From: Dawn Appleton [REDACTED]
Sent: 07 September 2015 15:56
To: Anita Gardner
Subject: RE: R/181/15/PL The Tiled Barn, Station Road

From: Anita Gardner
Sent: 04 September 2015 15:51
To: Dawn Appleton
Subject: R/181/15/PL The Tiled Barn, Station Road

I have now received the comments of the tree officer which can be viewed on line. He is objecting to the application and requesting that T9 is retained and not removed and I would therefore appreciate it if the tree can be indicated for retention on the submitted plan.

PROJECT			Proposed development on site adjacent to Tiled Barn, Station Road, East Preston	
SUBJECT			Proposed Site Plan and Location Plan	
SCALE	DATE	DRAWING No	2014 / 32 / 10	
DRAWN	CHECKED			
			Rev A

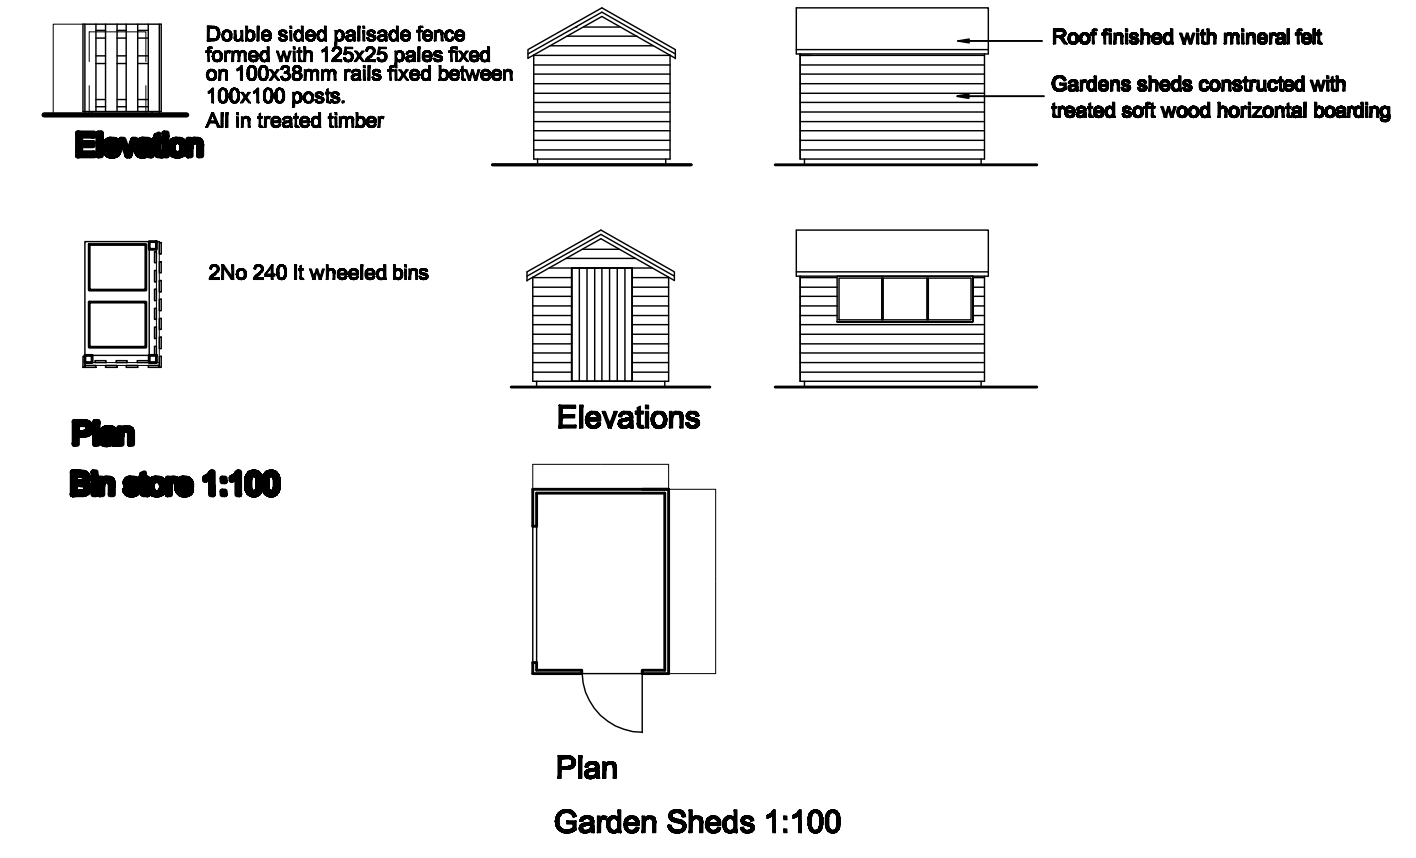
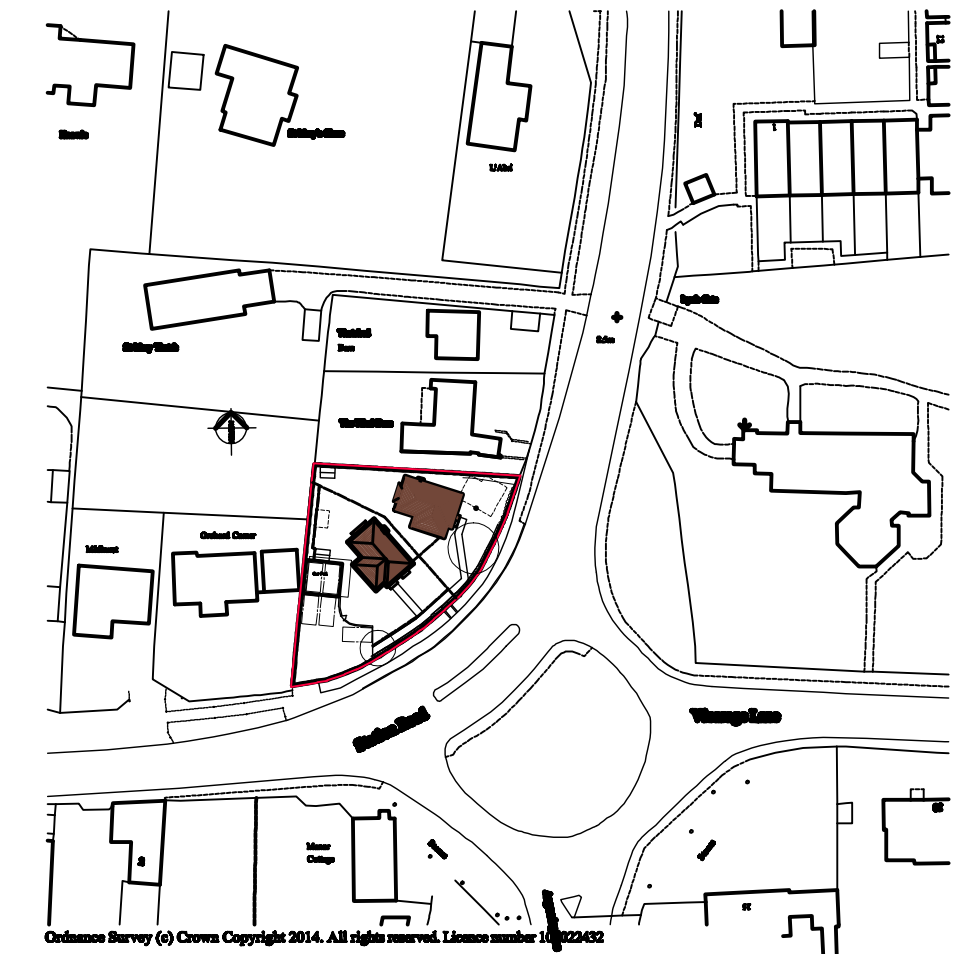
I have managed to get the application on September Committee on the basis that the tree is not being removed so would appreciate revised plans ASAP.

Please find attached revised site plan showing retention of T9 as requested. As I have already stated, I think a TPO is overkill given that it is already protected by the CA status. My client was not involved in the previous application for the removal of the other tree on the site.
